4 August 2025
Our Ref: 22379A.2KM_SUB

**Re: Objection to SSD-75660711 - Crows OSD Site A – Detailed SSDA
32 Hume Street, Crows Nest**

Sheet title
Overall Arrangement Elevation
East Elevation

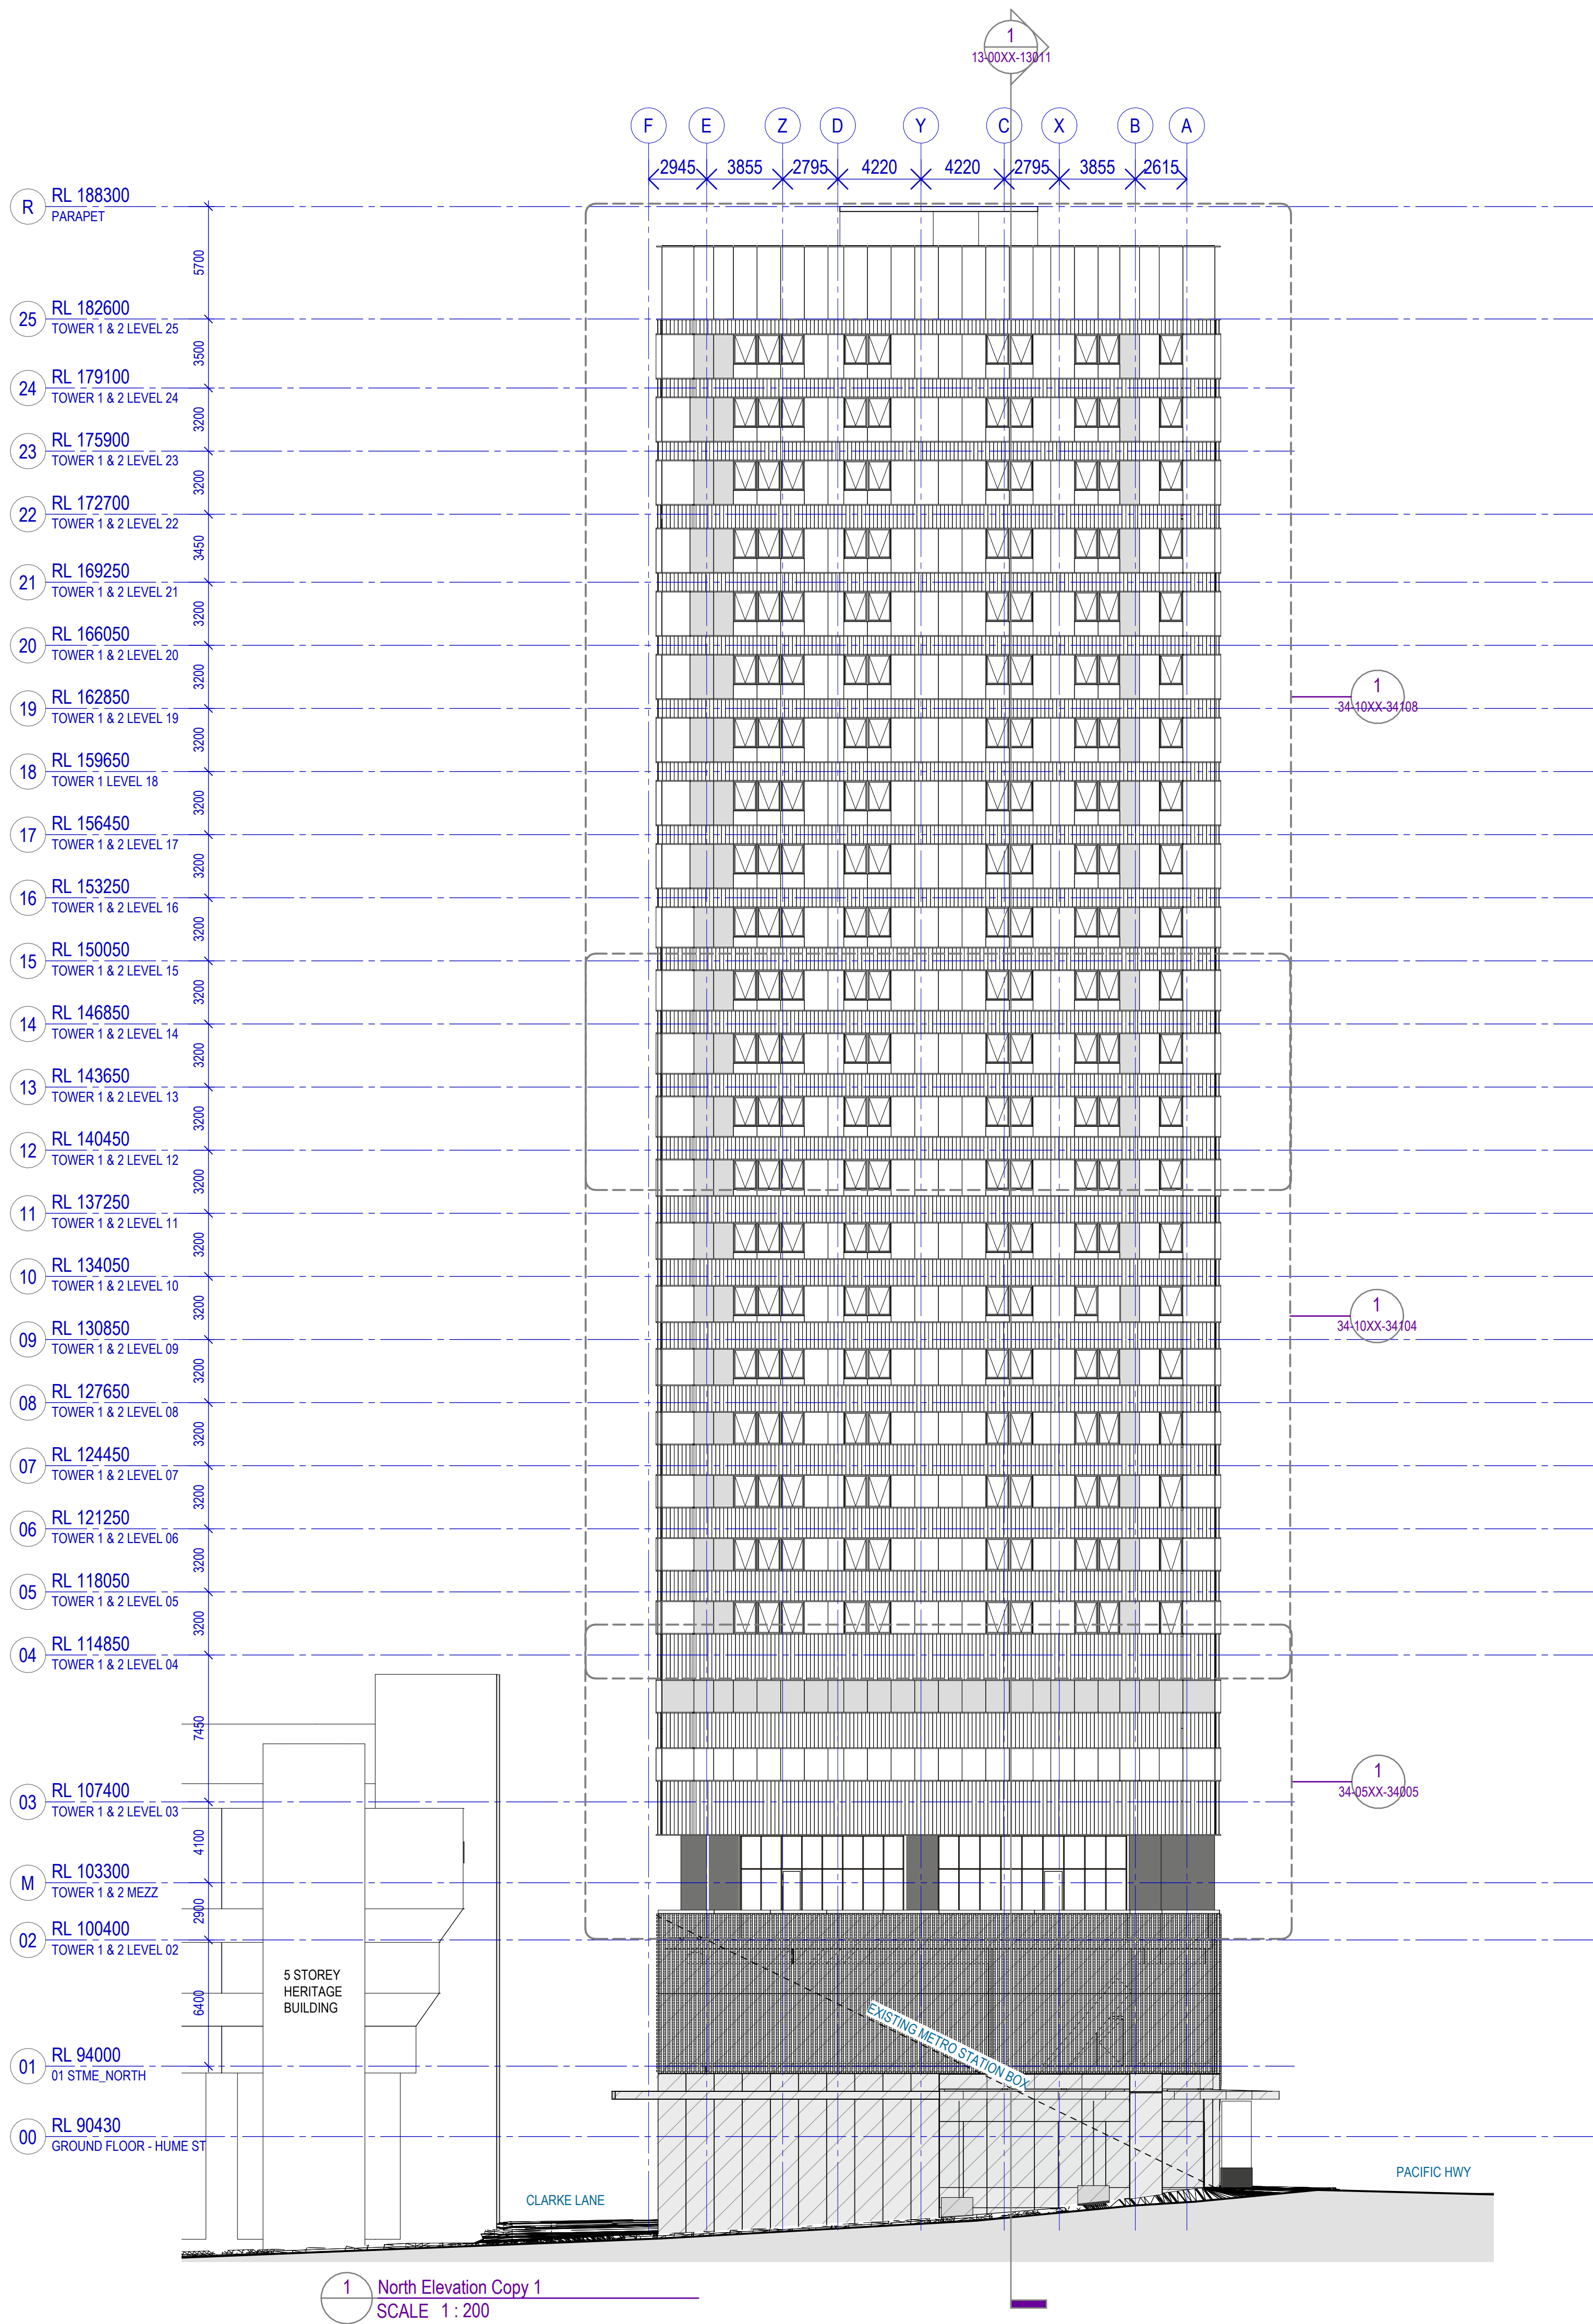
As can be seen in **Figure 3**, the Development Site boundary is defined by a dashed red line and we estimate that the distance between the eastern site boundary and Tower 1 to be approximately 2.5m. However, the Development Site boundary is not identified on the Applicant's elevations or section drawings, of which an extract is included in **Figure 4** above.

Accordingly, it is unclear from the proposed plans and elevations, where the eastern façade of Tower 1 sits relative to the eastern boundary of the Development Site.

We recommend that DPHI clarify this - if the proposed Tower 1 has no setback to the eastern boundary of the Development Site, the adverse impacts on our Client's Land will be exacerbated.

The ADG requires a distance of 9m at 5-8 storeys and 12m above 8 storeys. With a boundary setback of only 2.5m, Tower 1 provides for a setback from the centreline of the lane of only 5.5475m at all residential levels of the proposed building.

As shown in **Figure 4**, this would result in a situation where a future tower on Our Client's Land that was compliant with the ADG requirements (i.e. half the width of the required building separation) would be setback 14.5475m at 5-8 storeys (instead of the required 18m) and 17.5475m above 8 storeys (instead of the required 24m).
